# TIERRA WEST, LLC

April 13, 2021

**RE: UNSER/MCMAHON MIXED USE 10715 UNSER BLVD  
EROSION AND SEDIMENT CONTROL PLAN  
RESPONSE TO COMMENTS (A11E017)**

ENGINEER'S SEAL	UNSER & McMAHON
		Unser Blvd & McMahon Blvd
		EROSION CONTROL PLAN
		SHEET #
		ECP-1
		JOB #
		2020015

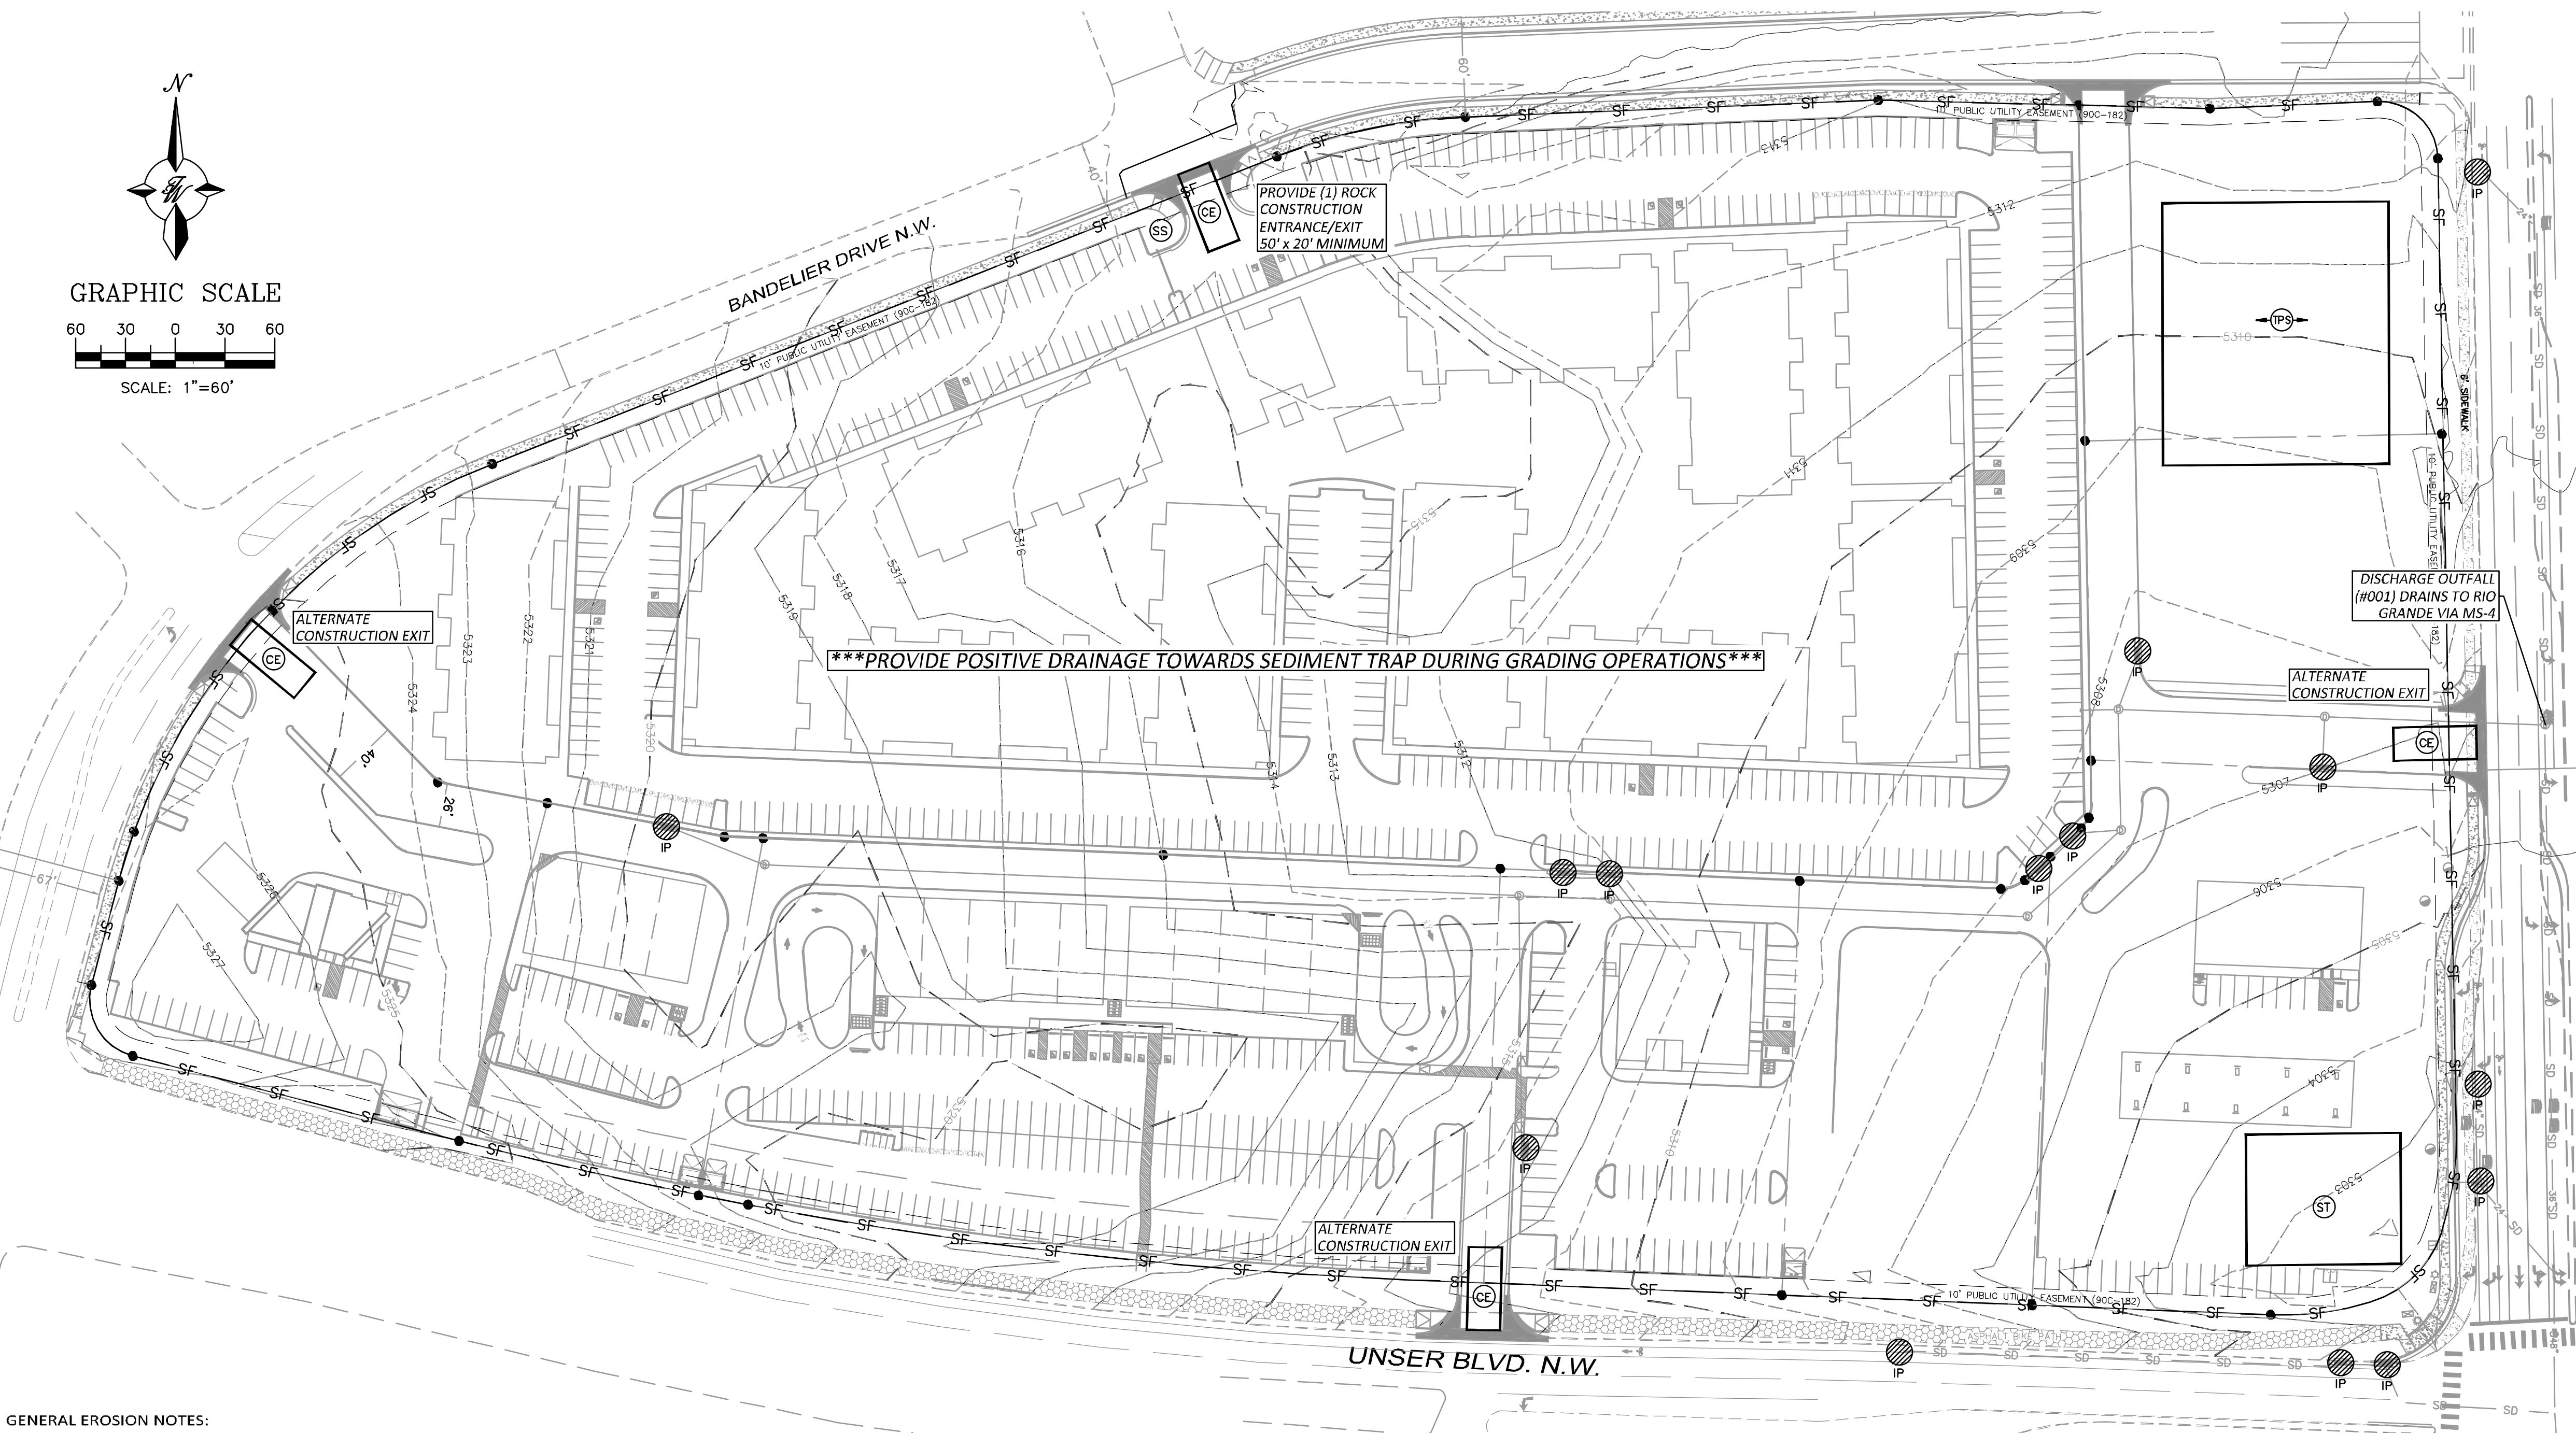
1. The north arrow is pointing west.  
**Response: The north arrow is now oriented in the correct direction.**
2. The limits of disturbance must include all frontage improvements (CGP7.2.4.b.i).

4. The locations of structures and other impervious surfaces. Differentiate between existing, construction this project, and future construction by others (CGP7.2.4.b.v).

5. Describe undisturbed and pre-construction ground cover (CGP7.2.4.e).  
**Response: The pre-construction ground cover description can now be found on the plan at the bottom of the Legend table. The ground cover described is undisturbed and uncompacted soil with native vegetation.**

6. List operators on the plan, including name, phone #, and email address. If unknown, leave blanks to be filled in later (CGP7.2.1).  
**Response: Operators are unknown at this time, so a "List of Operators" to be filled out at a later date is now shown near the lower right corner of the plan.**

7. Identify stormwater team members responsible for sediment removal, BMP maintenance, and inspections on the plan, including name, phone #, and email address. If unknown, leave blanks to be filled in later (CGP7.2.2).

8. Describe the nature and extent of construction activities (CGP7.2.2), including a) nature of construction activities, b) size of the property, c) size of disturbed area, d) description of construction support activities, e) size of maximum disturbed area, and f) project schedule. The three phases of this project are Grading, Infrastructure, and Sales. Provide a brief description of the nature of each phase. Include in the schedule the initial establishment of the sediment trap before the grading phase, the removal of the sediment trap and placement of additional silt fence to keep sediment out of the onsite street after the infrastructure phase, and the annual maintenance plan of the BMP's and stabilization practices (temporary and permanent) during the sales phase. Describe the expected circumstances of Termination of permit coverage including a final stabilization specification or sale and transfer to other operators. The operators and team members for each phase should be identified in 6 and 7 above.

9. Stabilization measures (CGP7.2.6.b.vi), including a) specific vegetative and non-vegetative practices, b) deadlines, c) beginning and ending dates of the seasonably dry period, d) procedure to comply with The Weed Removal Ordinance (§ 9-8-1) during sales phase:

10. Soil Information – add a table with name type, particle sizes, and erodibility factor (CGP2.1.1)

12. Vicinity Map – add a zone atlas map clearly indicating location and street names.

13. City Standard ESC Notes attached.

**Response: The plans have been updated to show the limits of disturbance to include all frontage improvements. This includes 1) the driveway entrances off of Unser, McMahon, and Bandelier, 2) the Bandelier roadway extension to McMahon, and 3) the sidewalk along the existing Bandelier Road. Sidewalks and trails already exist along Unser and McMahon frontage so the limits of disturbance come up to the back of those walks.**

**Response: The plan has been updated to show only what is to be constructed in this project. The scope of work in this project includes mass grading, storm drain installation, paving of access road internal to site, and the frontage improvements as mentioned in comment response #2.**

**Response: Stormwater team members are unknown at this time, so a "Stormwater Team Members" section to be filled out a later date is now shown near the lower right corner of the plan.**

**Response: A "Nature and Extent of Construction Activities" notes section has been added to the plan to include all of this information. This would include, nature of construction activities, property size, disturbed area size, description of construction support activities, max disturbed area, project schedule, grading phases, infrastructure phase, sales phase, annual inspections, NOT termination, stabilization measures, and City Weed Removal Ordinance. A BMP maintenance notes section is also shown on this plan sheet.**

**Response: The added "Nature and Extent of Construction Activities" notes section on this sheet includes the stabilization measures.**

**Response: A soil information table has been added to the lower right corner of the plan identifying this soil information.**

**Response: Vicinity/zone atlas map has been added to the upper right corner of the plan.**

**Response: The city standard ESC notes have been added to the lower left corner of the plan.**
